**RE: PPR-18-026 New Widefield PK-8 School  
First Submittal**

Please see below for response (*in blue italics*) to **PCD-Engineering Review Comments** for the above referenced project, dated July 9, 2018. Responses include input from project design engineers and consultants as follows: Drexel, Barrell & Co. for civil; William Guman & Associates for landscaping; LSC Transportation Consultants, Inc. for traffic.

**C3.2**

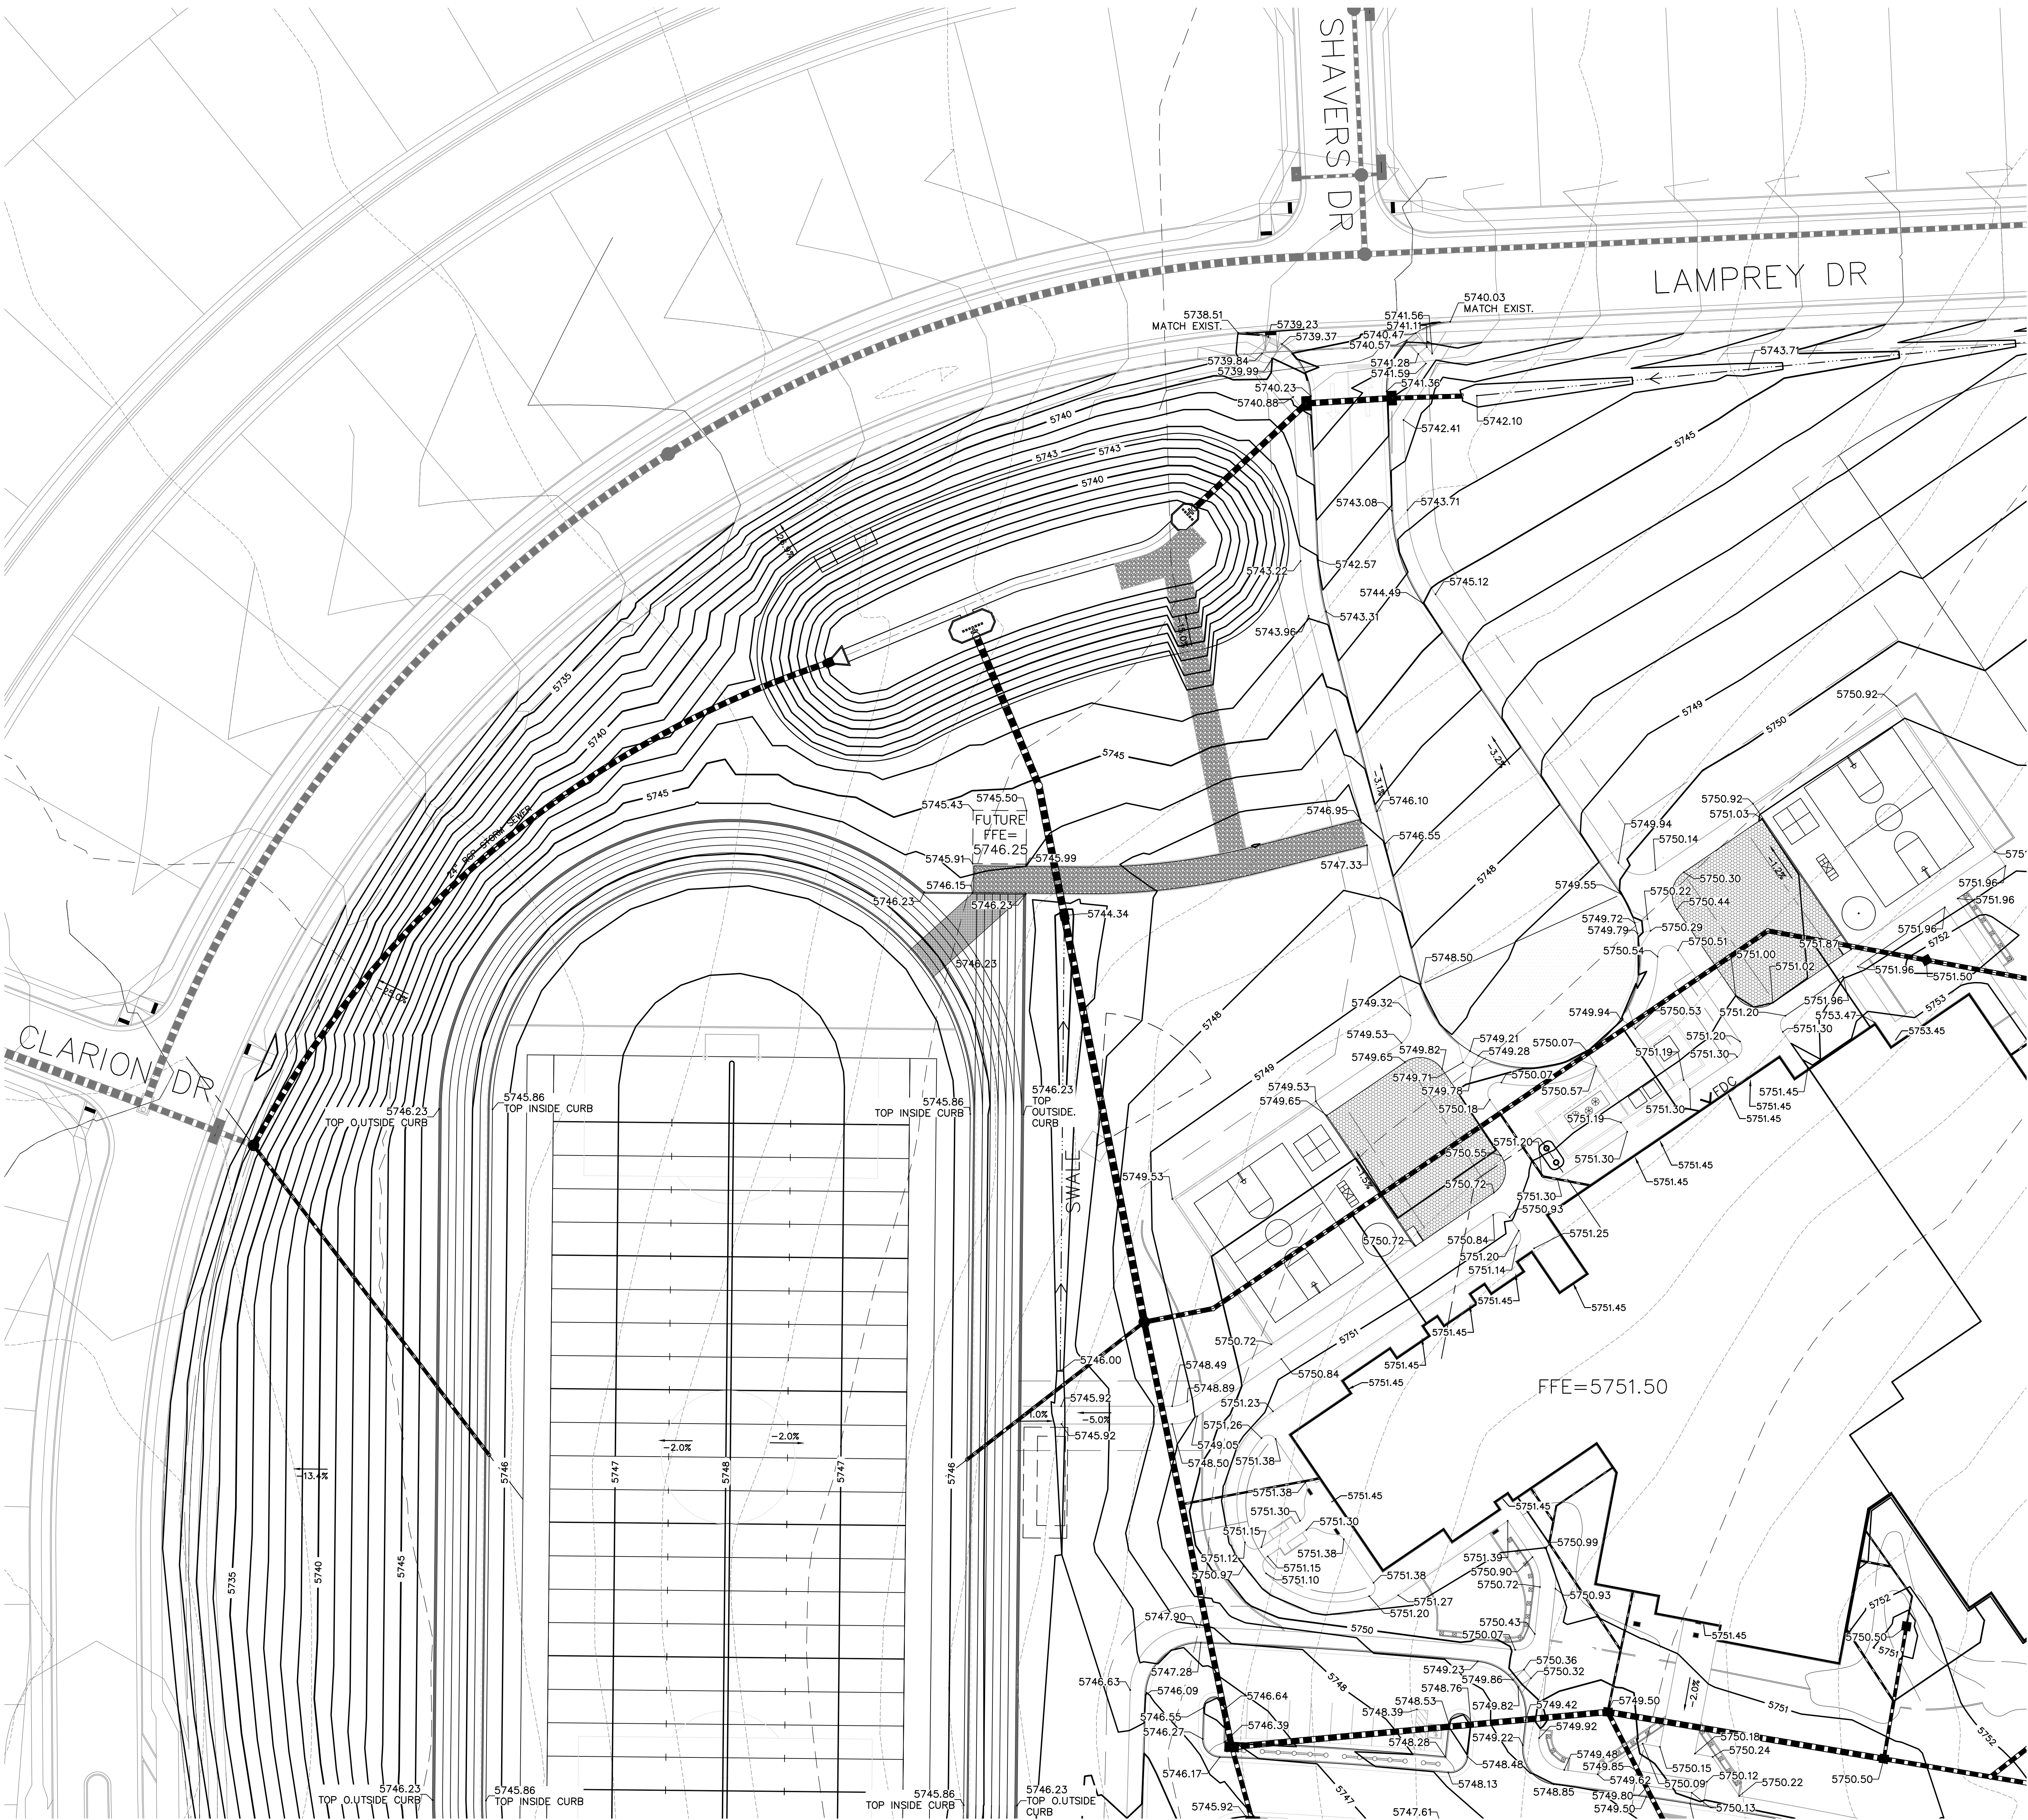
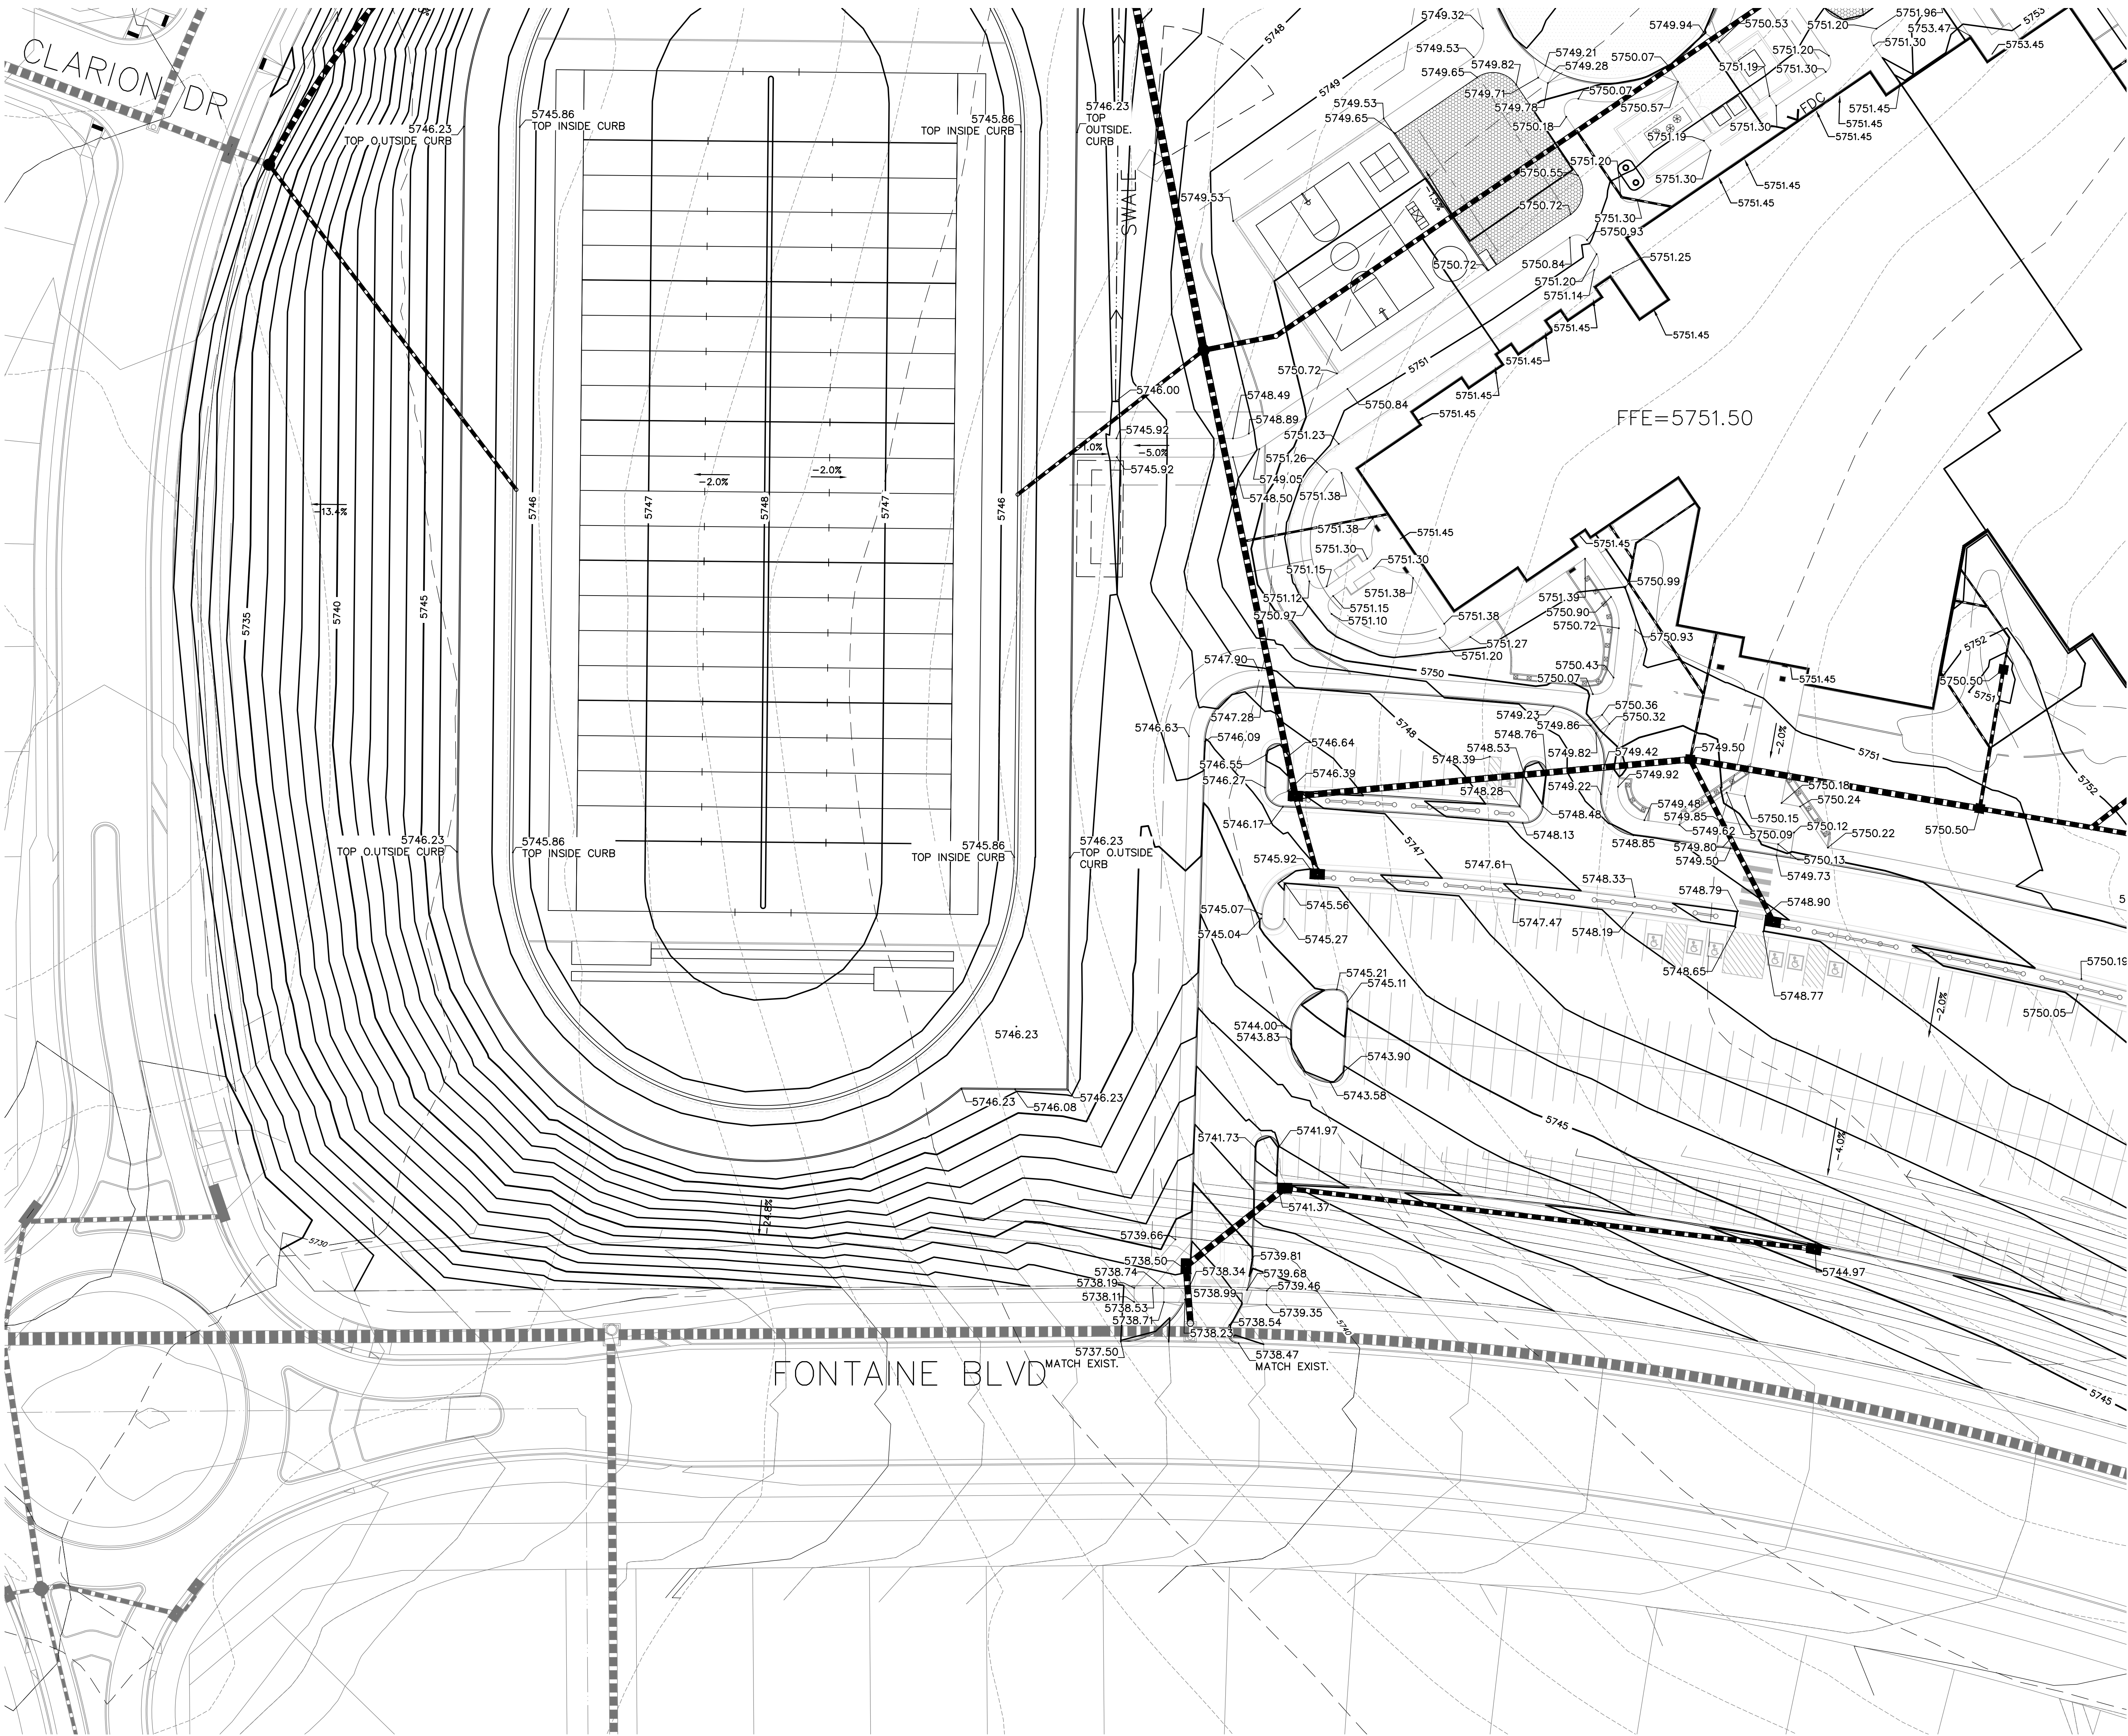
3. Provide construction details including spot elevations for all access points. **RESPONSE: See construction details on architectural SD sheets and spot elevations on civil C3-series sheets in resubmitted Site Development Plan.**

3. Provide construction details including spot elevations for all access points.  
***Construction details are on architectural sheets. Spot elevations are shown on Civil sheets C3.1-C3.4***
